From: Roger Spencer <Roger.Spencer@arun.gov.uk>
Sent: 09 July 2021 14:00
To: Simon Davis <Simon.Davis@arun.gov.uk>
Cc: Paul Cann <Paul.Cann@arun.gov.uk>; Laura Gibbons <Laura.Gibbons@arun.gov.uk>
Subject: RE: Burndell Rd, Yapton - Change to Agreed SuDS Scheme (ref Y/72/21/DOC)

Our comments relating to on-site issues are covered in the Application (5.1 of the Technical Note) and dealt with previously by email; there is no plan (drawing) of the ditch regrade option, it is however, dealt with at 3.5.1 of the same note, although we have not validated the claims set out therein.

TYPICAL HYDRO-BRAKE FLOW CONTROL CHAMBER DETAIL

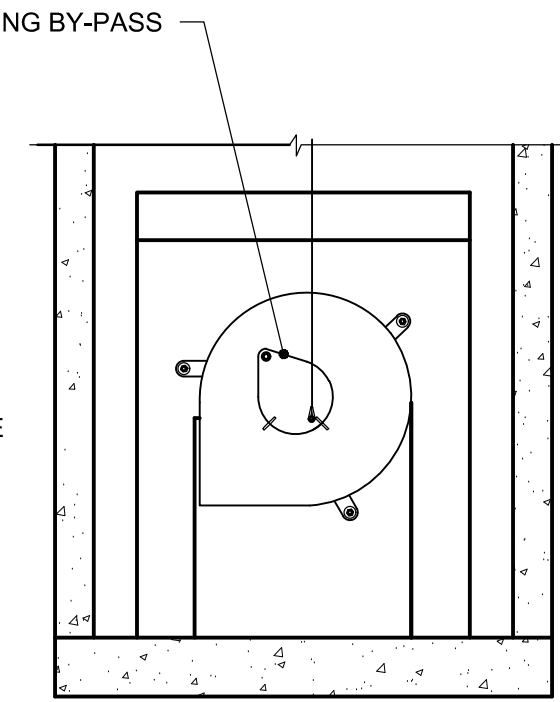
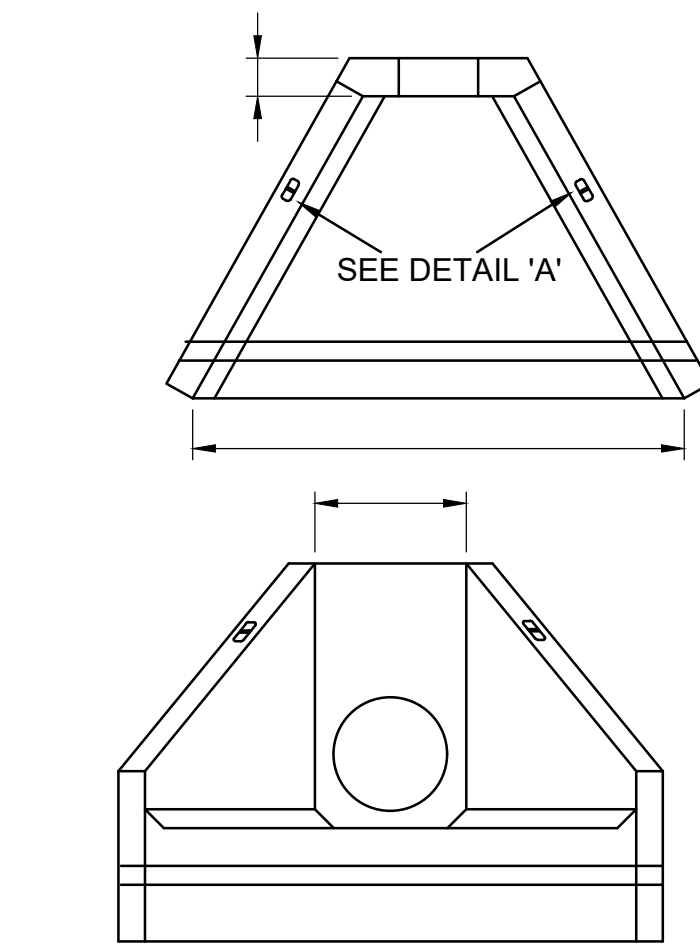
If I have misunderstood and Karl is wanting a plan of the proposed change to the drainage works, I would see that as being a detail extract of the larger area plan within the Application – being the change from the Hydrobrake manhole (MH S13) to the ditch (with the insertion of a pumping station) – probably over a distance of less than 10m.
